W T HARRIS BLVD.
PROPERTY

CONDITIONAL
REZONING PLAN

CHARLOTTE - MECKLENBURG
PLANNING COMMISSION
INTER - OFFICE COMMUNICATION

SUBJECT: Administrative Approval for Petition No. 95-37 by The Shelton Companies Tax Parcel # 099-293-01

CONDITIONAL  
REZONING PLAN

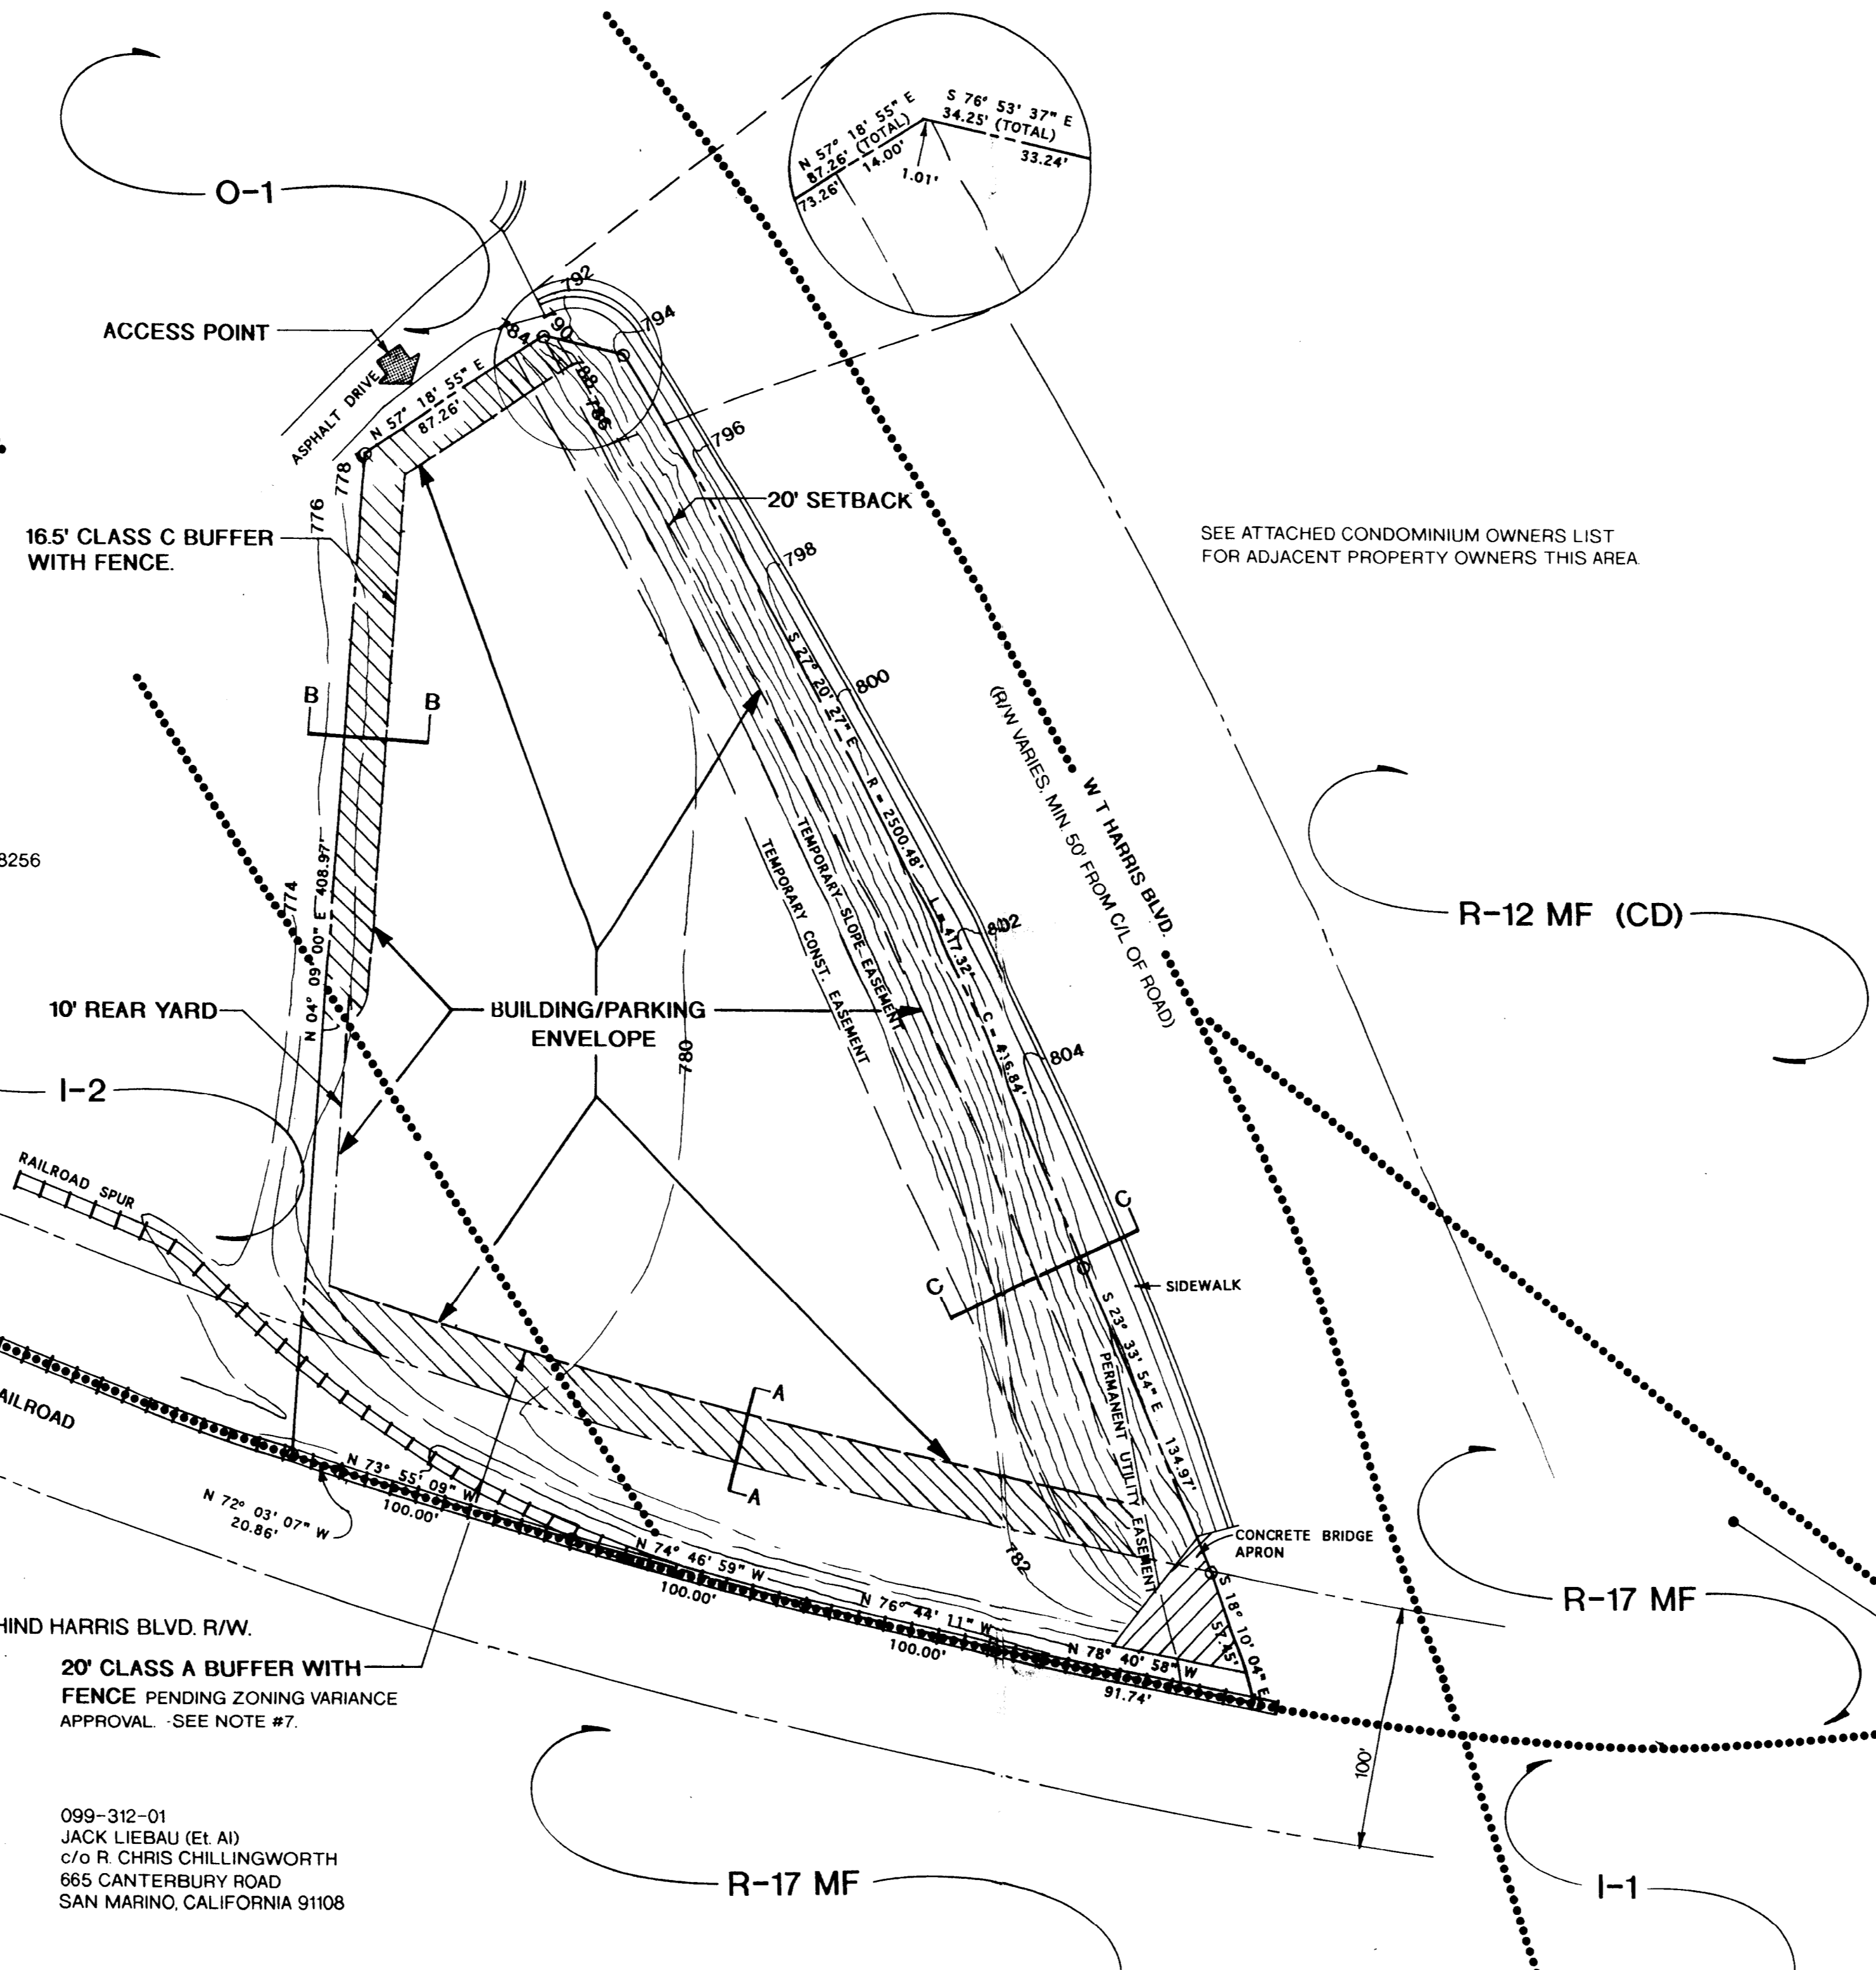
Attached is a revised plan for the above mentioned rezoning petition. The plan has been revised to show a smaller side yard/buffer adjacent to an Office and Industrial zoned parcel developed with a steel manufacturing plant. This revised plan will reduce the buffer along this property line from 16.5 feet to 10 feet. This buffer was originally approved at 16.5 feet because of the interpretation that mini-warehousing is considered an industrial use. However, a recent interpretation by the zoning administrator has determined that mini-warehousing is not an industrial use when located in an business district and does not require a buffer. Since this change is minor I am administratively approving this revised plan. Please use this revised plan when evaluating requests for building permits and certificates of occupancy.
